**RE: Suazo Residence Lot 8 Block 10 Unit 22 Volcano Cliffs  
6511 Petirrojo NW  
Grading and Drainage Plan  
Engineers Stamp Date 1/20/16 (D10D0003P8)**

## DRAINAGE AND TRANSPORTATION INFORMATION SHEET (REV 09/2015)

**RE: Suazo Residence Lot 8 Block 10 Unit 22 Volcano Cliffs  
6511 Petirrojo NW  
Grading and Drainage Plan  
Engineers Stamp Date 1/15/16 (D10D0003P8)**

ENGINEER'S SEAL	LOT 8, BLOCK 10, UNIT 18 VOLCANO CLIFFS SUBDIVISION	DRAWN BY JDG
	GRADING AND DRAINAGE PLAN	DATE 01-14-2015
		SHEET # 1 OF 1
1/15/16		JOB #
DAVID SOULE P.E. #14522	1606 CENTRAL AVENUE SE SUITE 201 ALBUQUERQUE, NM 87106 (505) 872-0999

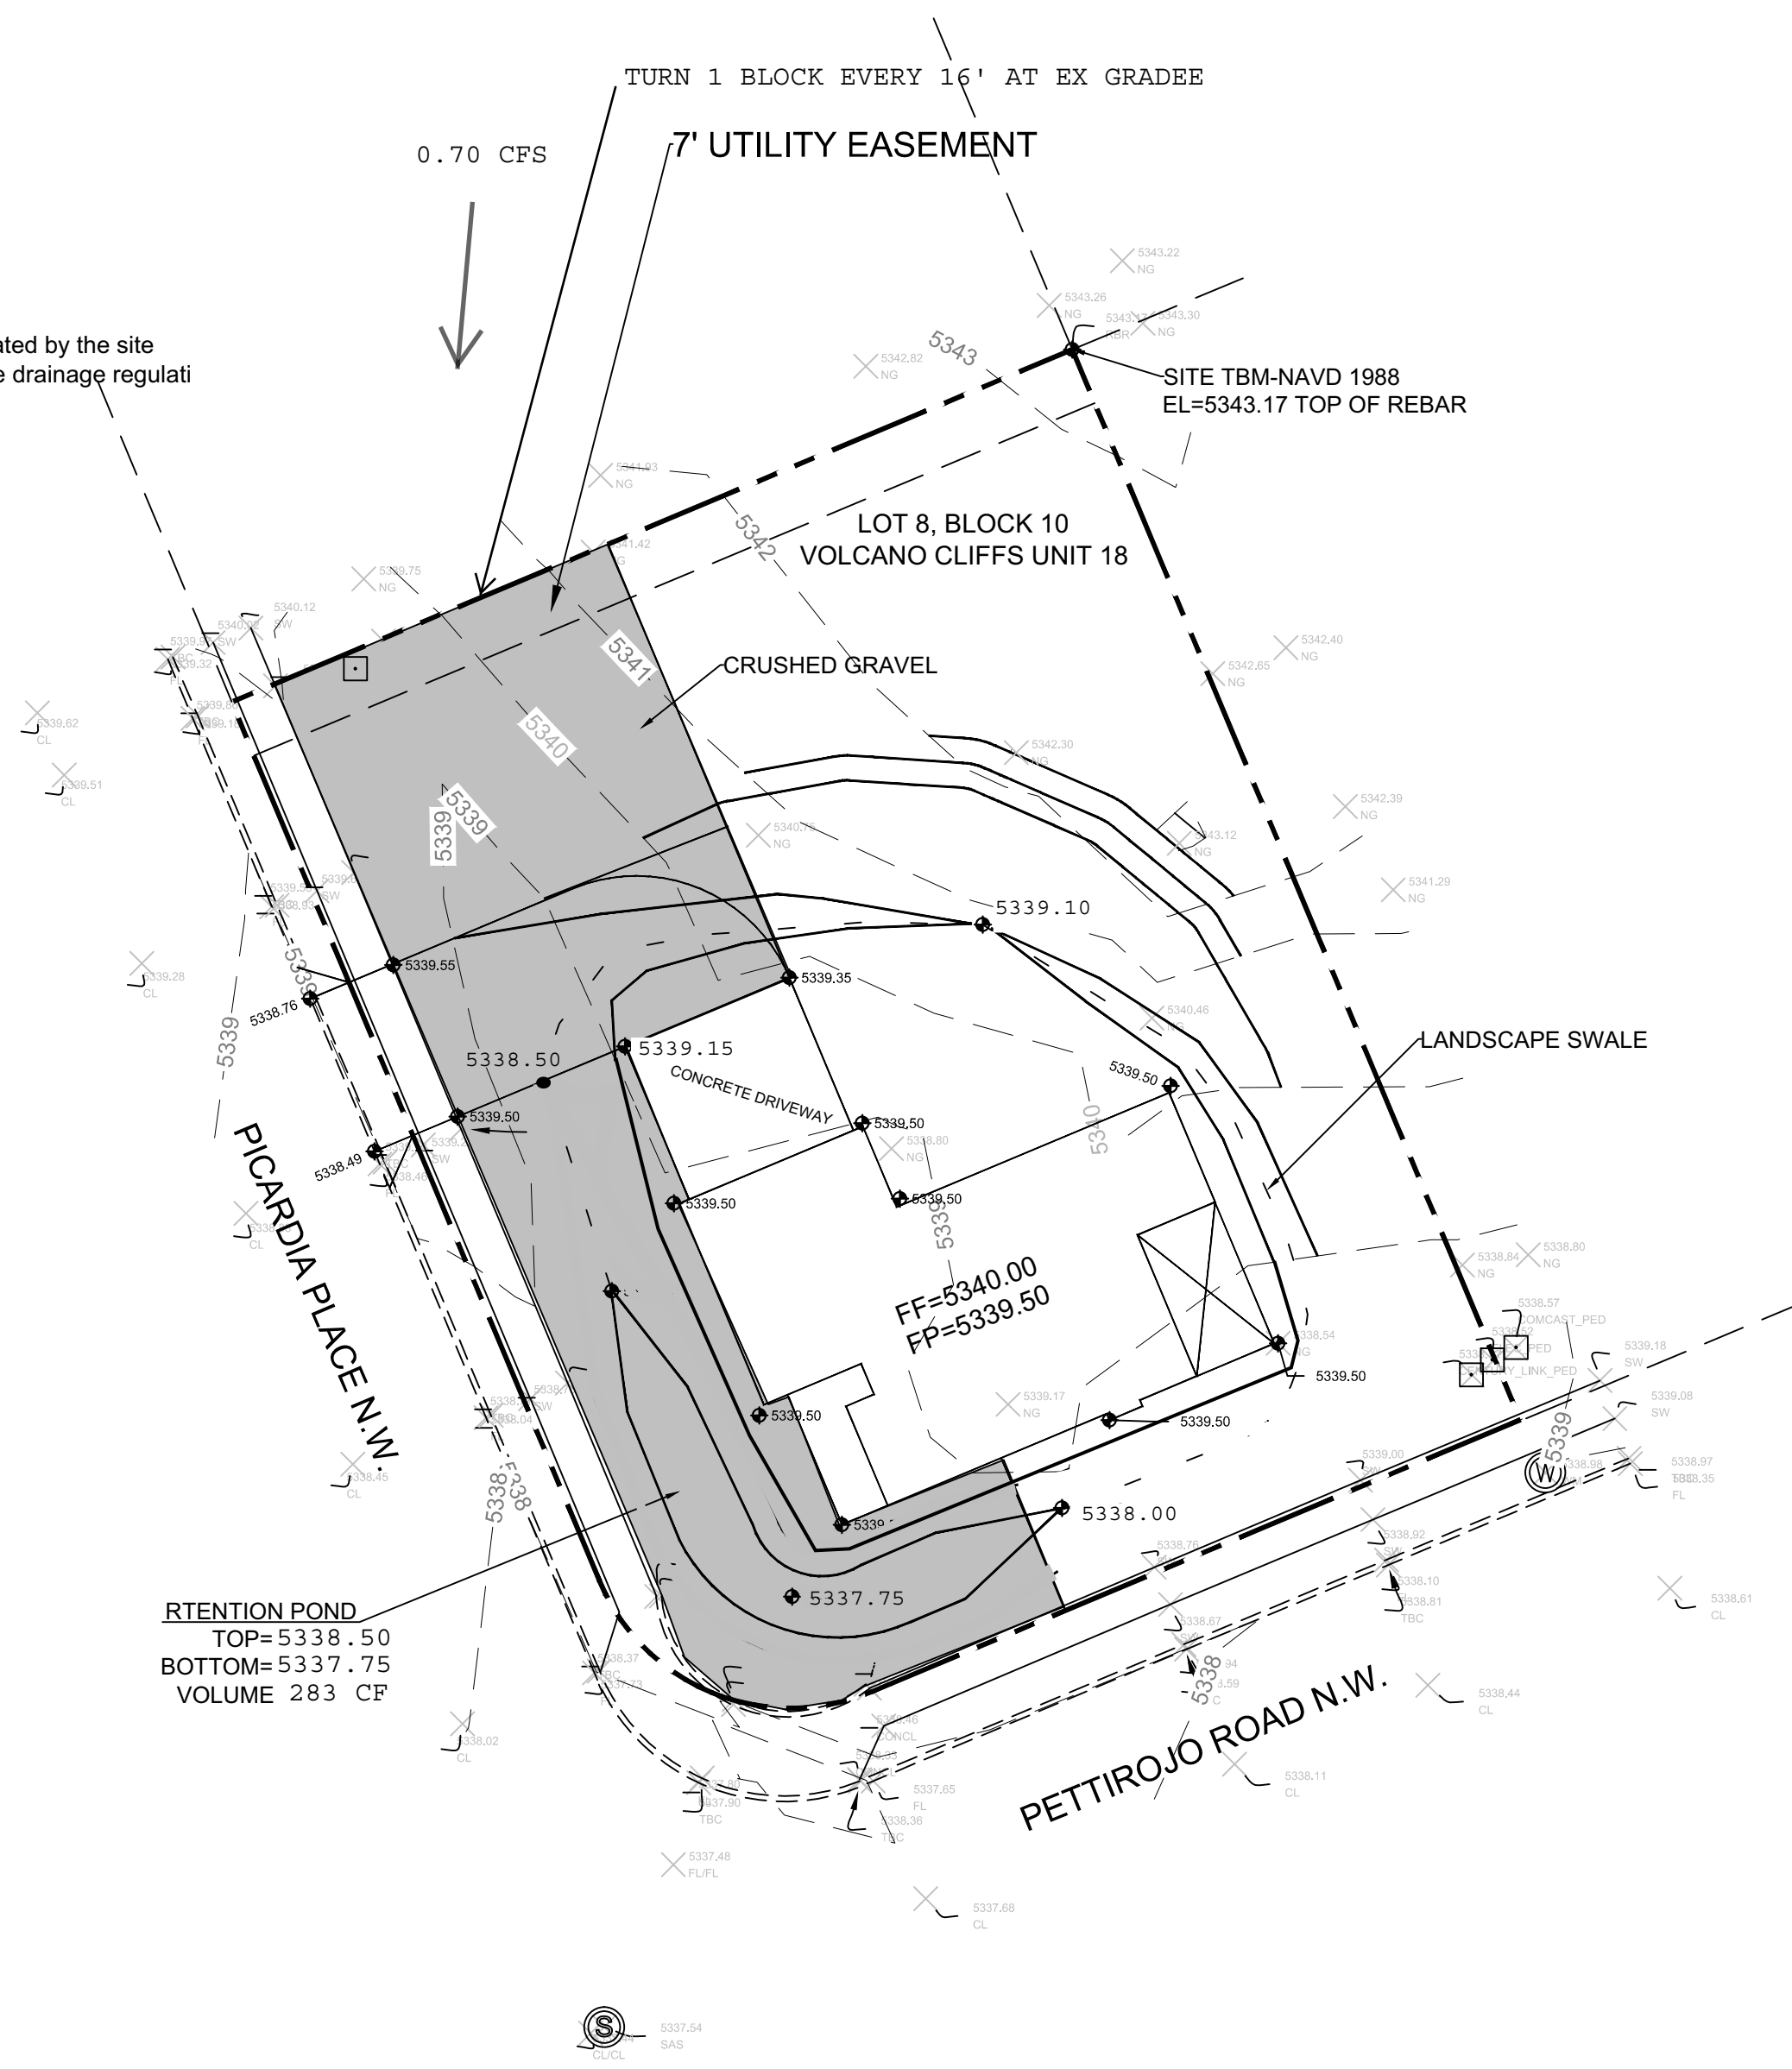
- Provide turn blocks in the east and west rear yard walls to allow flows to pass through and into the double sidewalk culvert in Picardia Place.

**ADDED NOTE TO TURN BLOCK**
